# CITY OF PORTLAND BUILDING PERMIT

Job ID: 2011-09-2271-CH OF USE

has permission to Do 1st floor restaurant fit up, 24'x17.5' rear deck with landing & steps, add steps to rear of ramp  
provided that the person or persons, firm or corporation accepting this permit shall comply with all of the provisions of  
the Statues of Maine and of the Ordinances of the City of Portland regulating the construction, maintenance and use of  
the buildings and structures, and of the application on file in the department.

Job ID: 2011-09-2271-CH OF USE

NEW DECK & RAMP PLAN

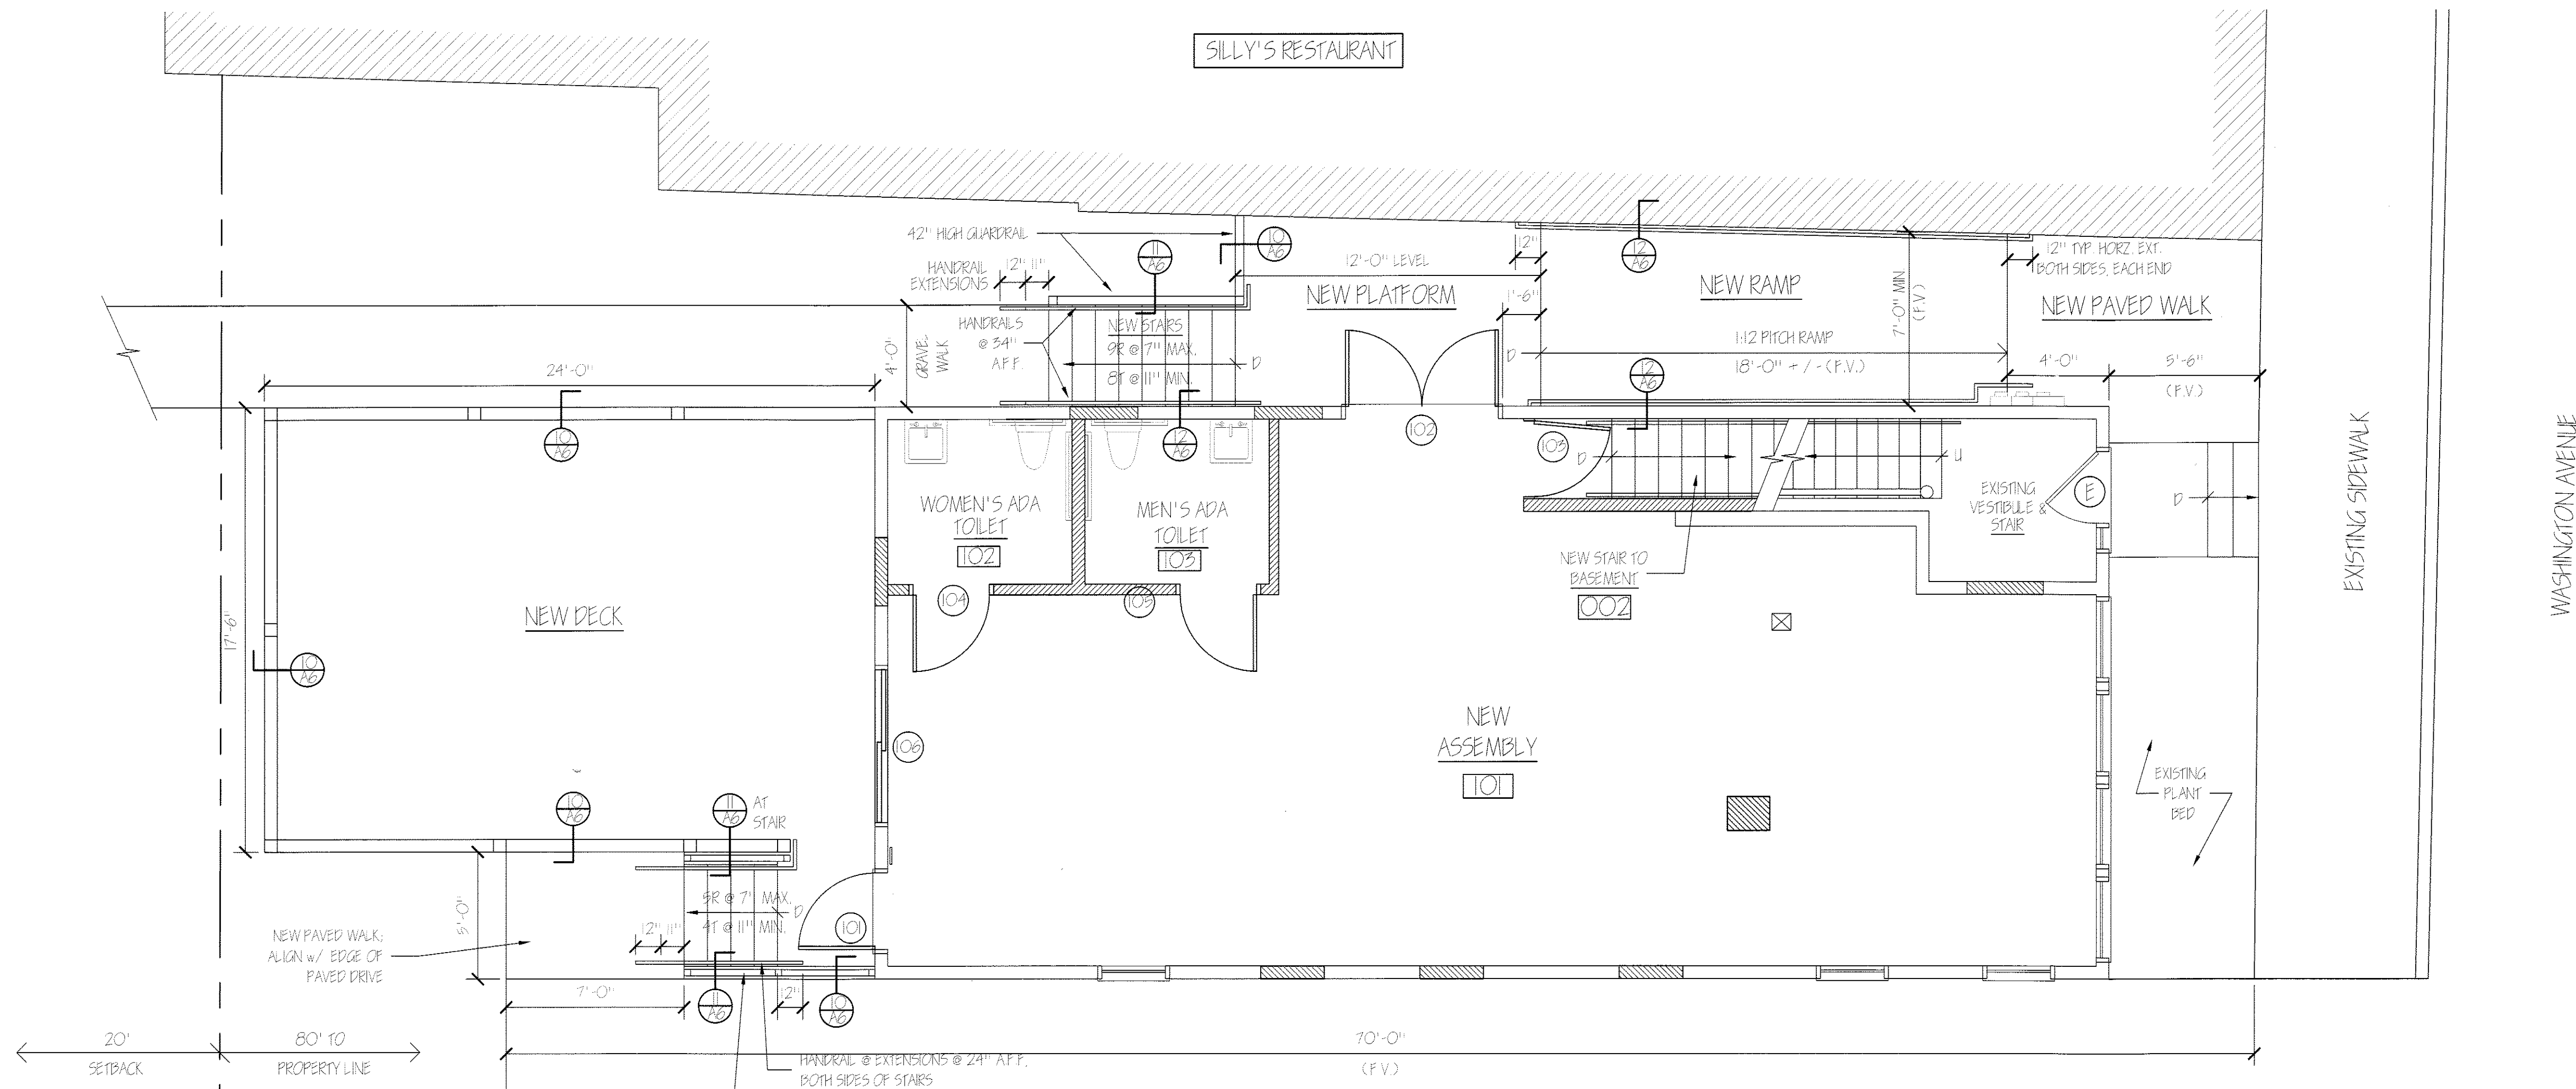
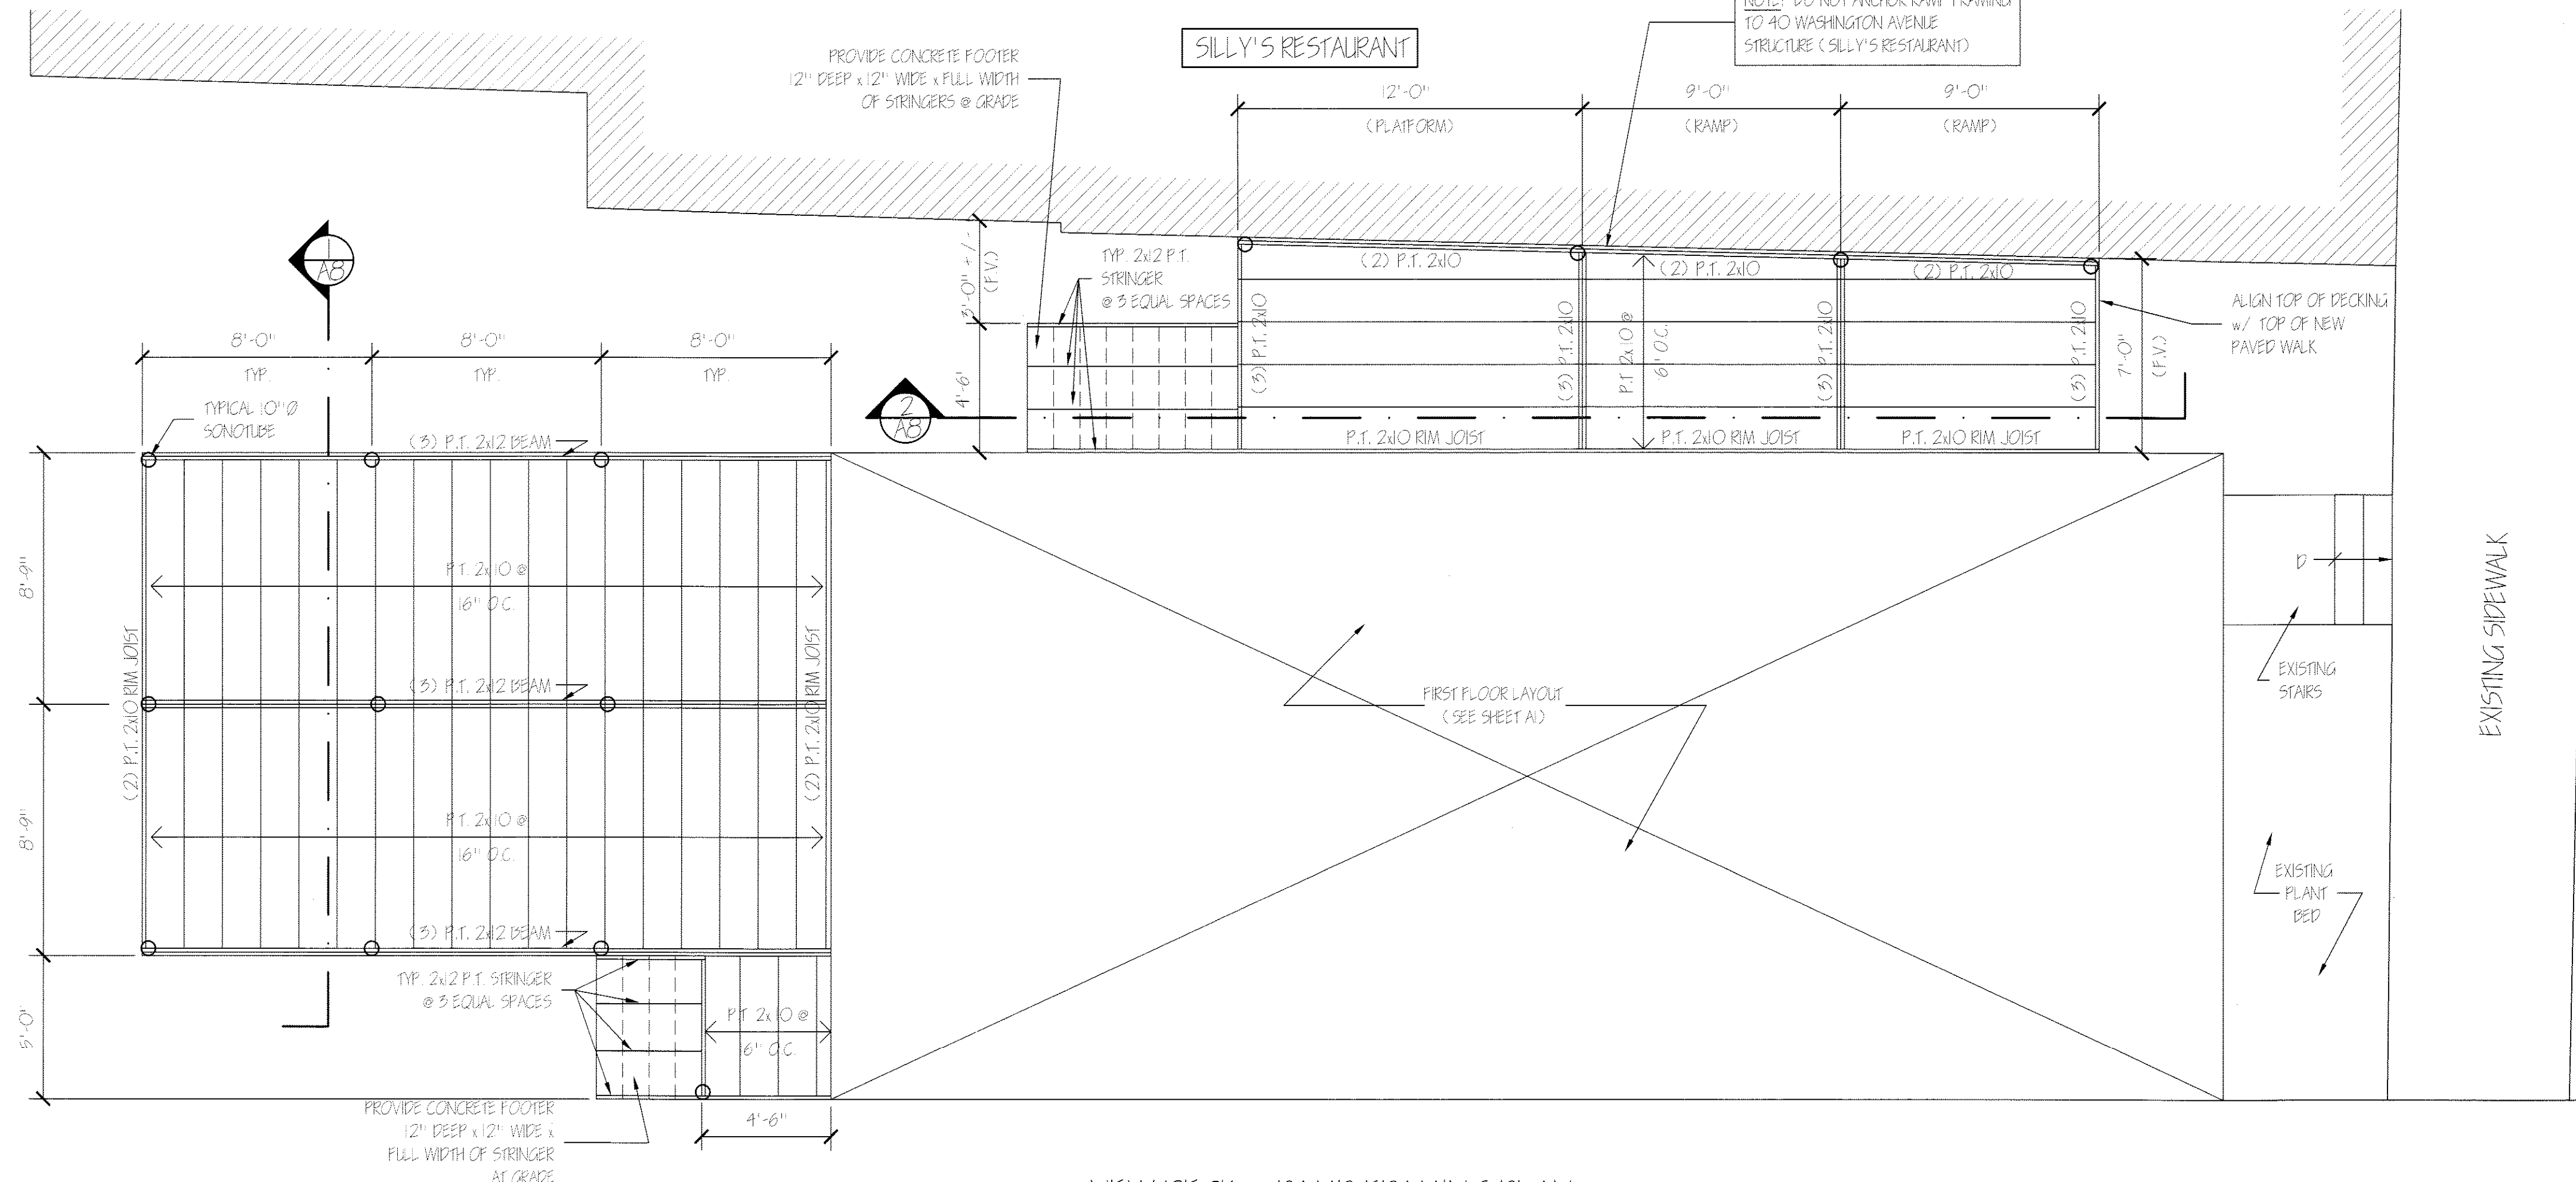
- The deck construction shall be as the original design on plan A1.1, the alternate design is not approved
